Ref No: D05723029

Subject: UNSW G25 Education Building

Thank you for the opportunity to comment on the State Significant Development Application for the UNSW G25 Education Building (SSD-74670005) – “Demolition of the existing at-grade carpark at location G25, site preparation works, and construction of a new teaching and learning building.”

Tree Removal and Replacement Plan

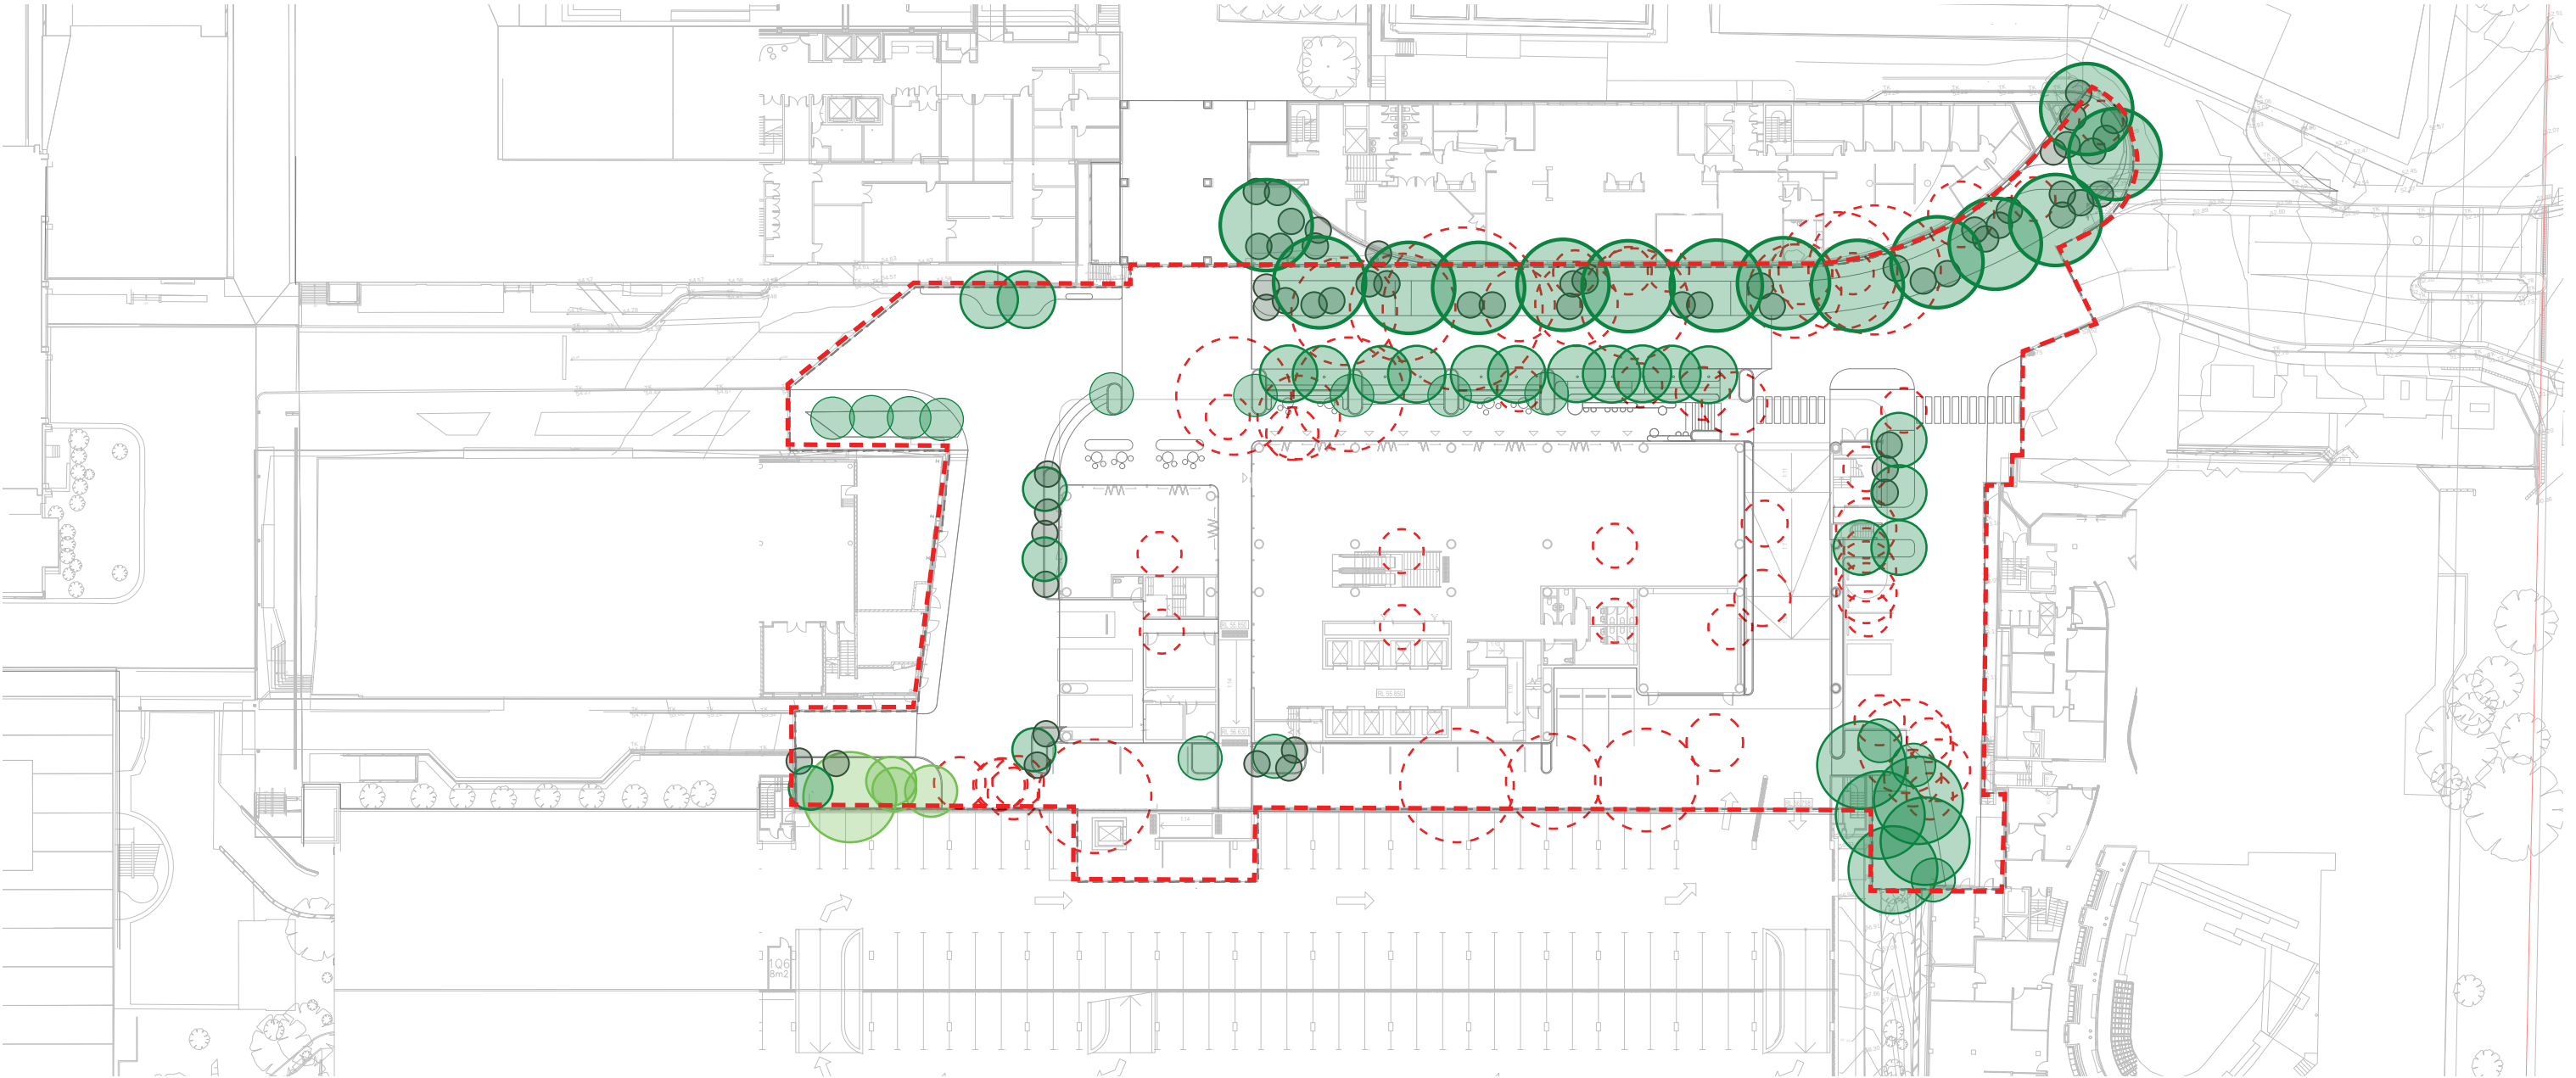
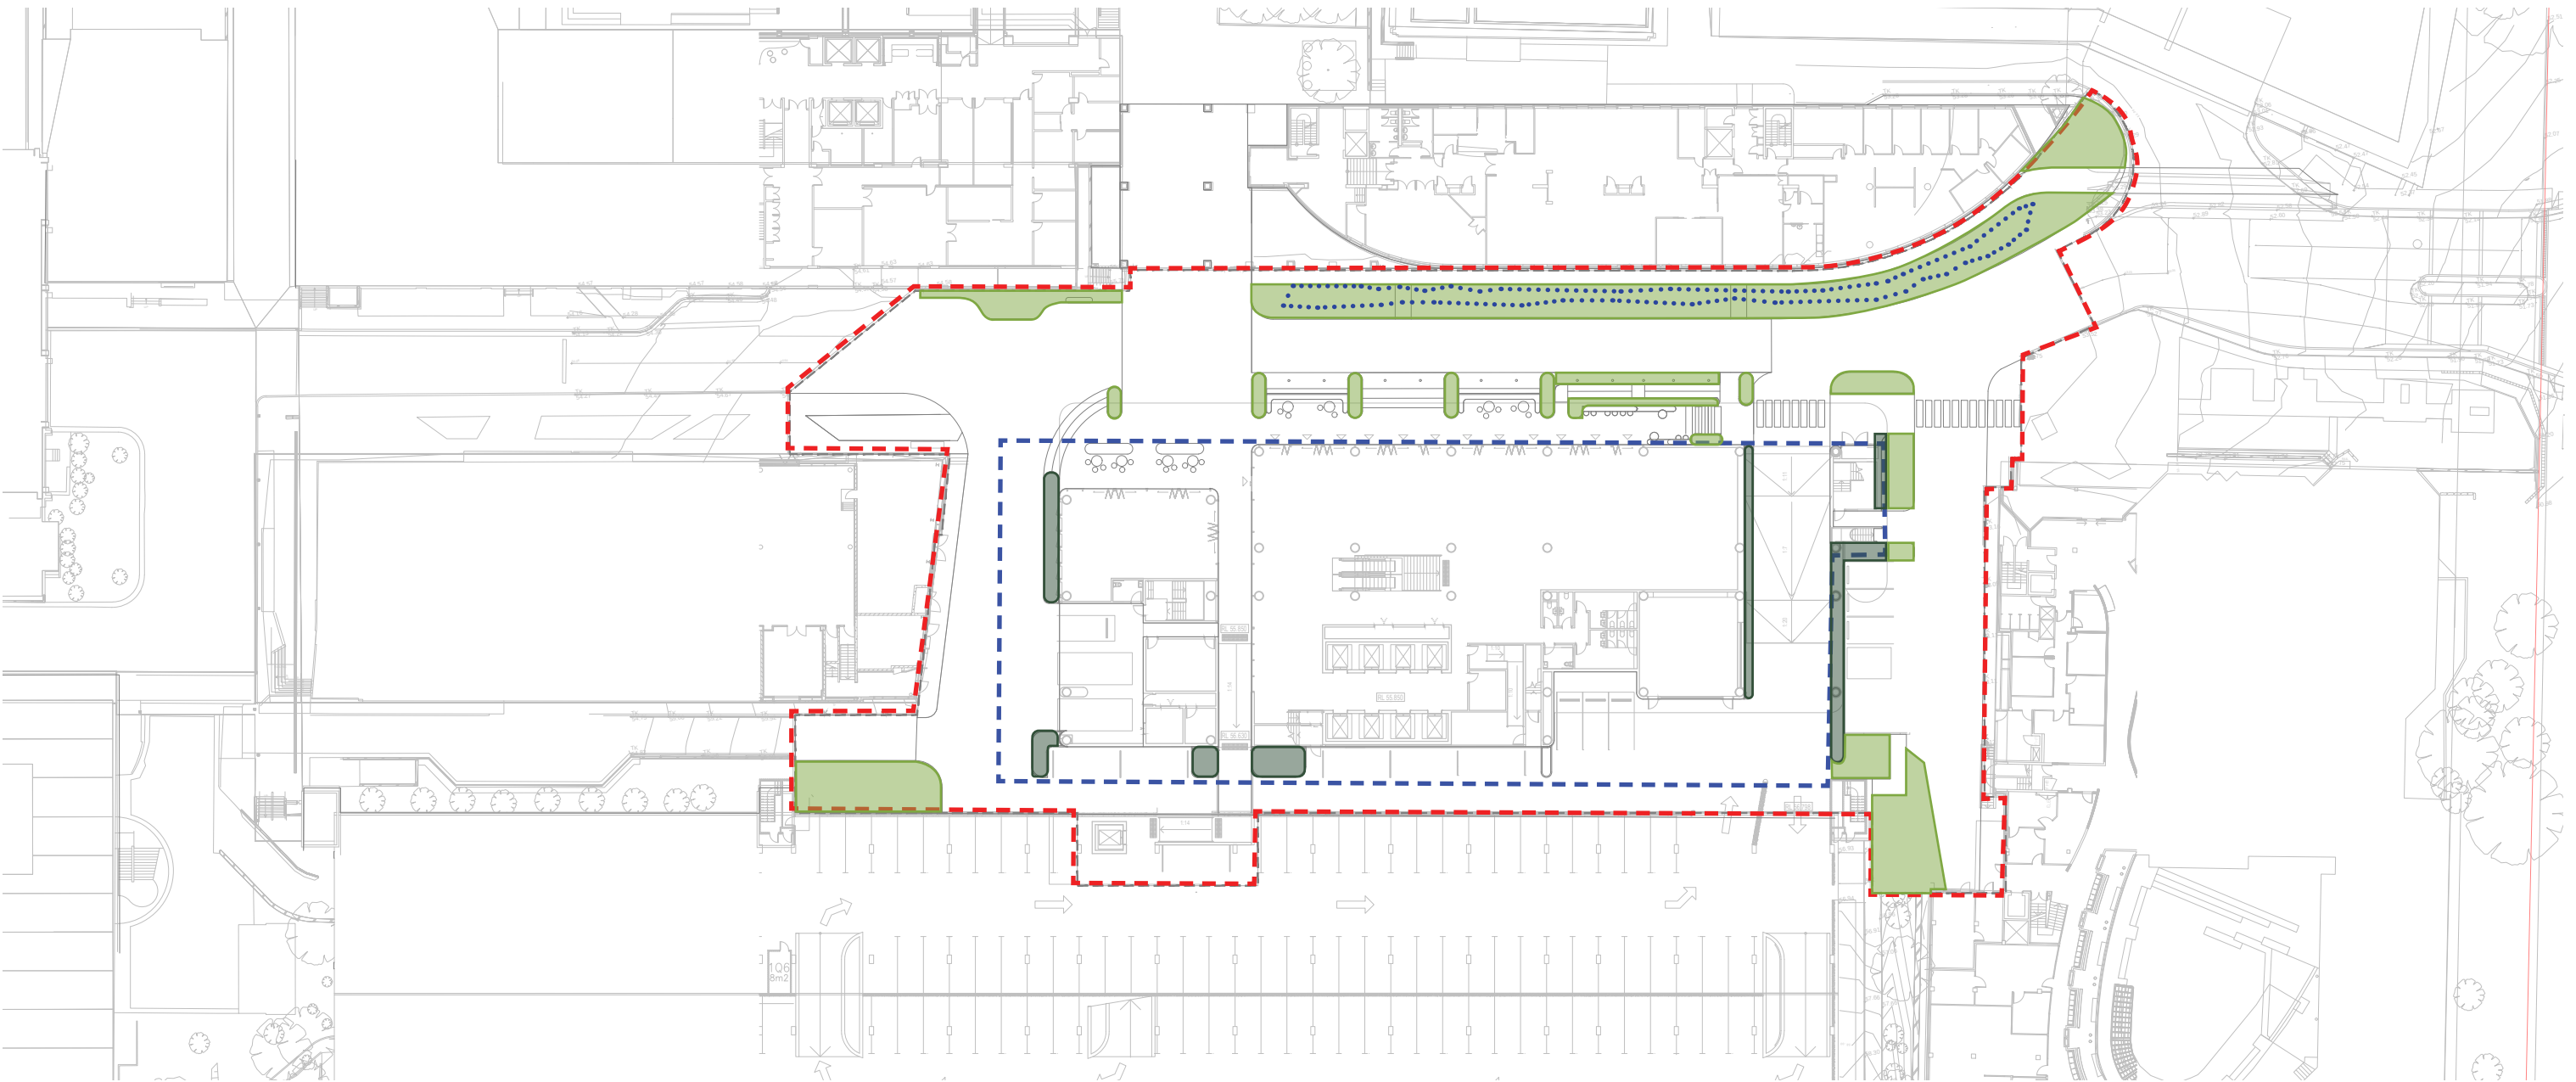
11. The EIS acknowledges the removal of 57 trees to construct the building, including some of high retention value. This is compensated through the planting of 110 trees and ferns. The proposal should clarify if all 110 trees or ferns will be planted within the proposed development area or throughout the campus. This should be indicated on the landscape plans.

Landscape Masterplan

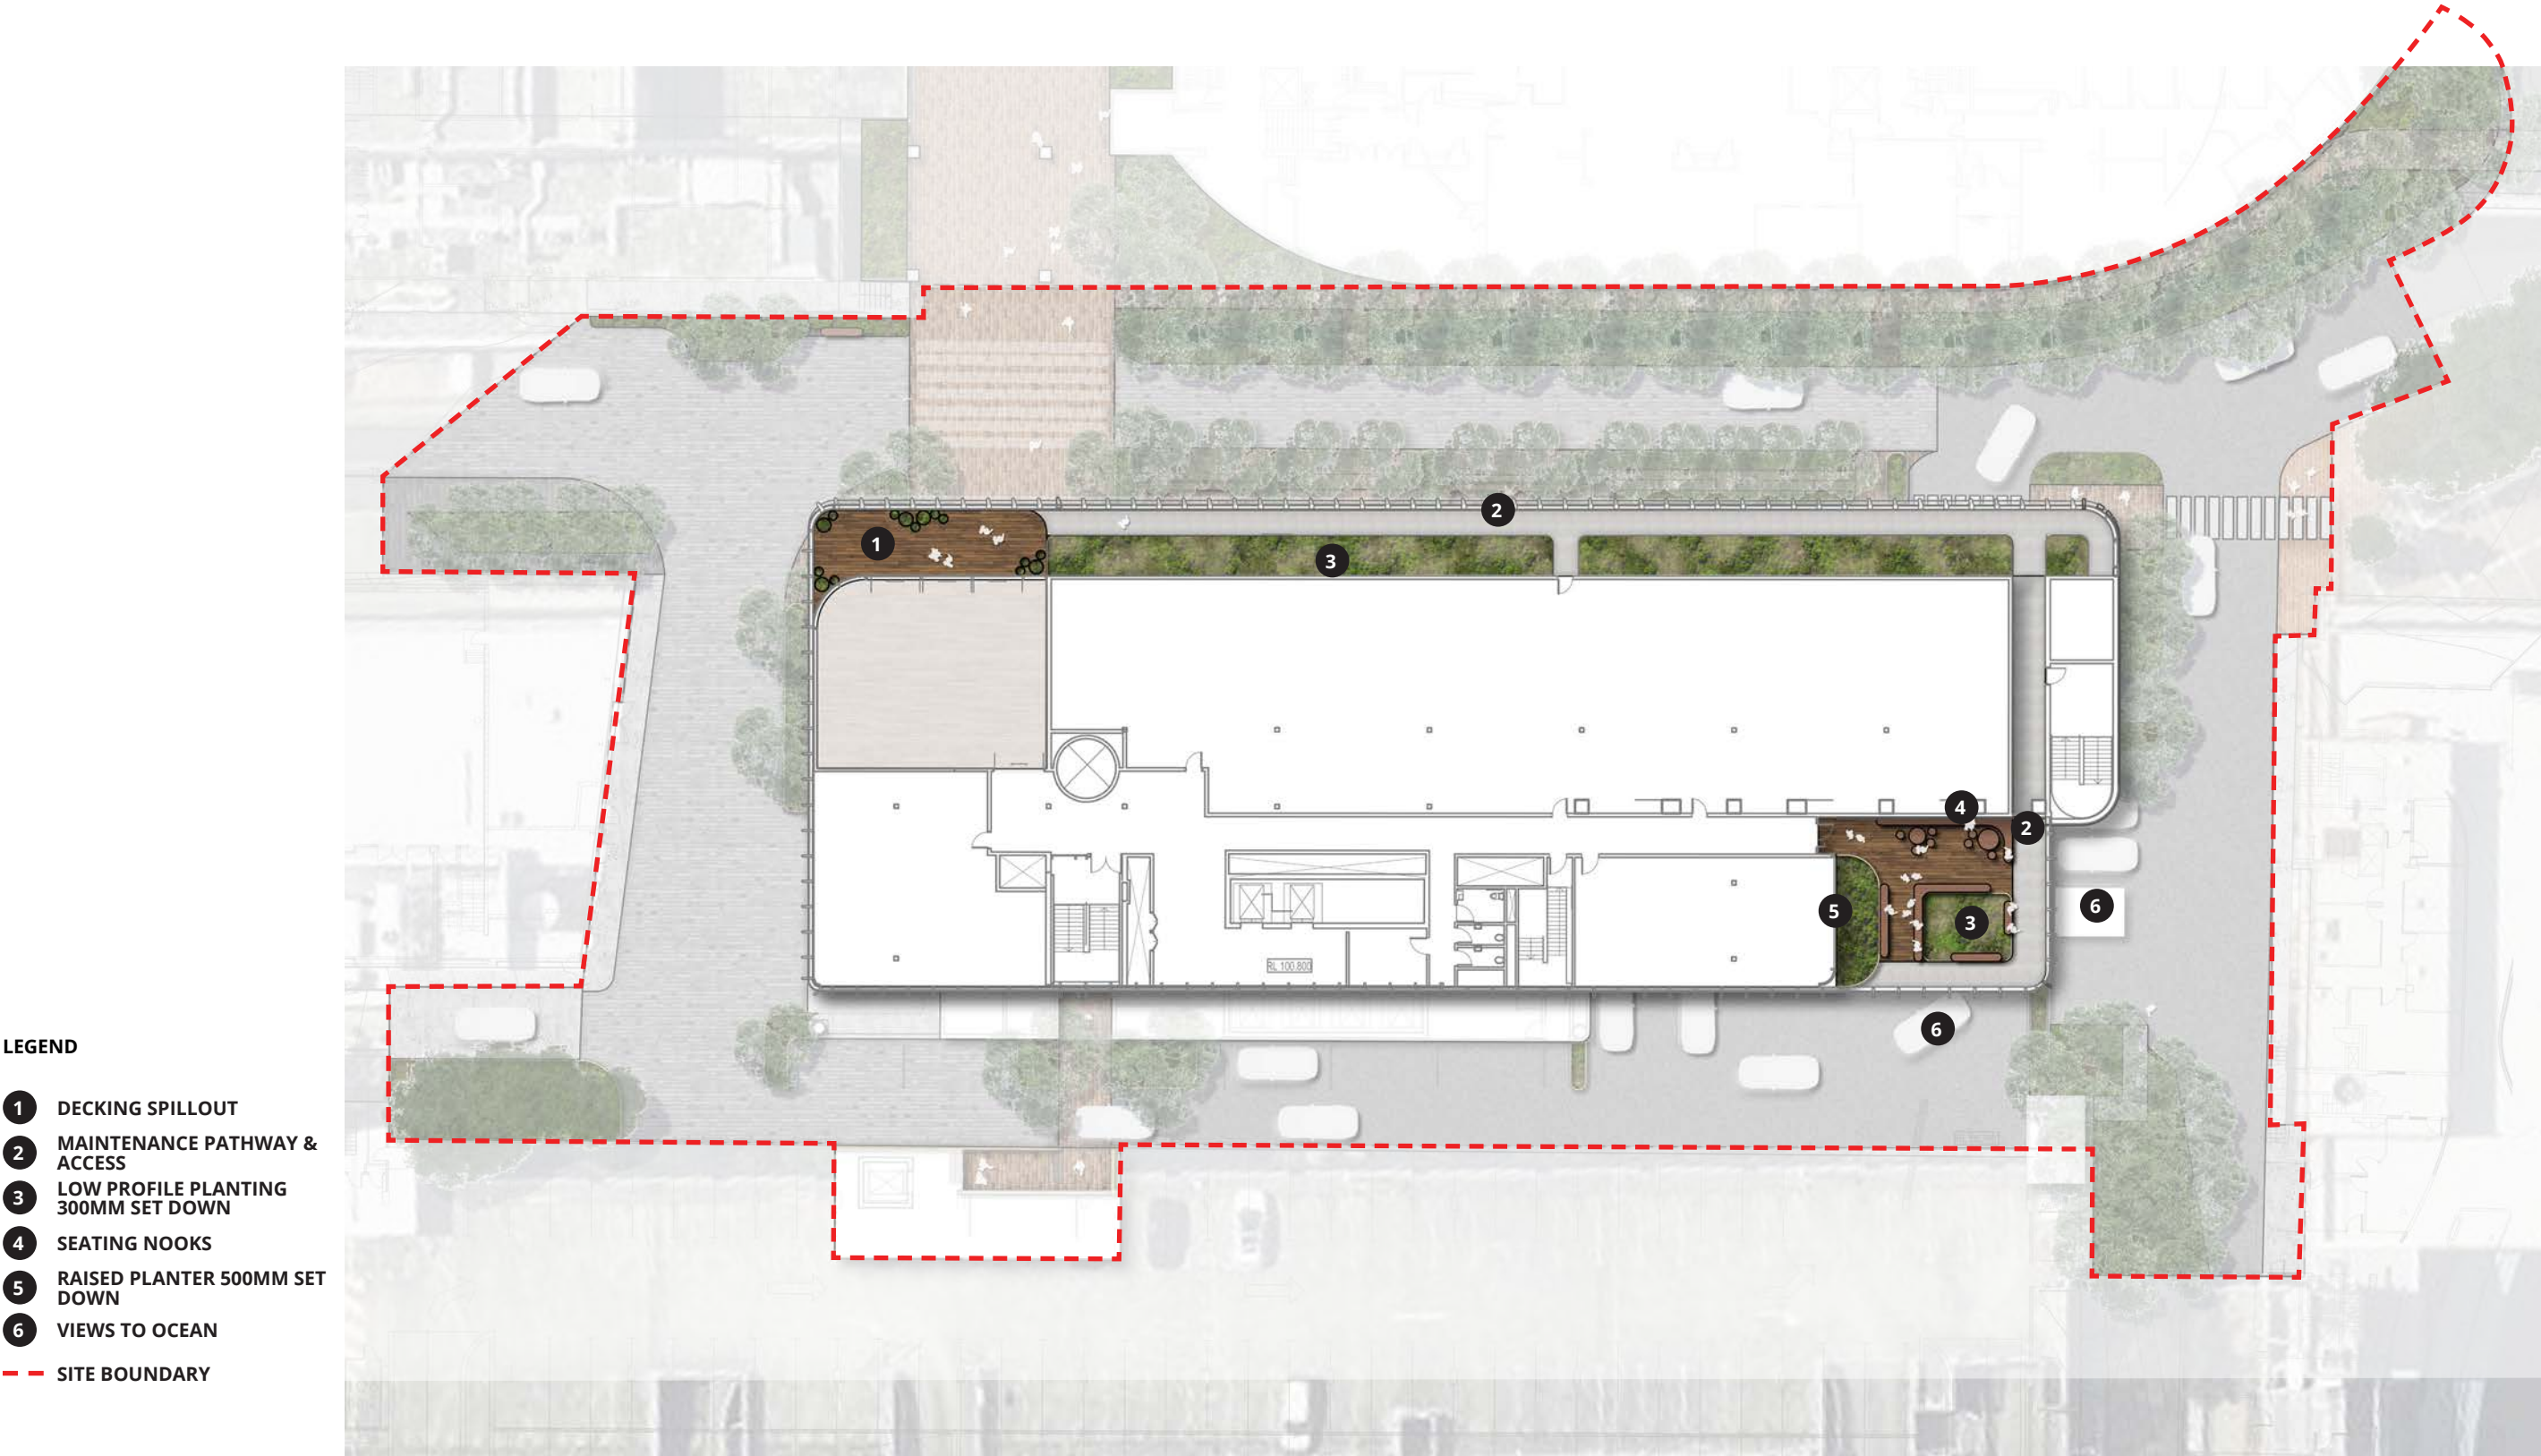
5. While the landscape design report (Appendix F) provides a detailed native planting palette, the vegetation proposed should be assessed for adequate solar and shade access as required and evident in the solar analysis. For example, the proposed native violet on the roof terrace would not be suited as the roof has intense sun with no/little shading options and native violet thrives in partial shade and damper environmental conditions, otherwise it will require high watering irrigation system.
6. The Randwick 2023 DCP Chapter – E2 - identifies the desired future character in section 4.2.2. Sense of place. Supporting these controls, Council recommends that the access/entry points along both Botany Street and High Street provide a strong frontage that defines the entry points, consistent with a possible future extension to the hospital complex as outlined in the DCP.
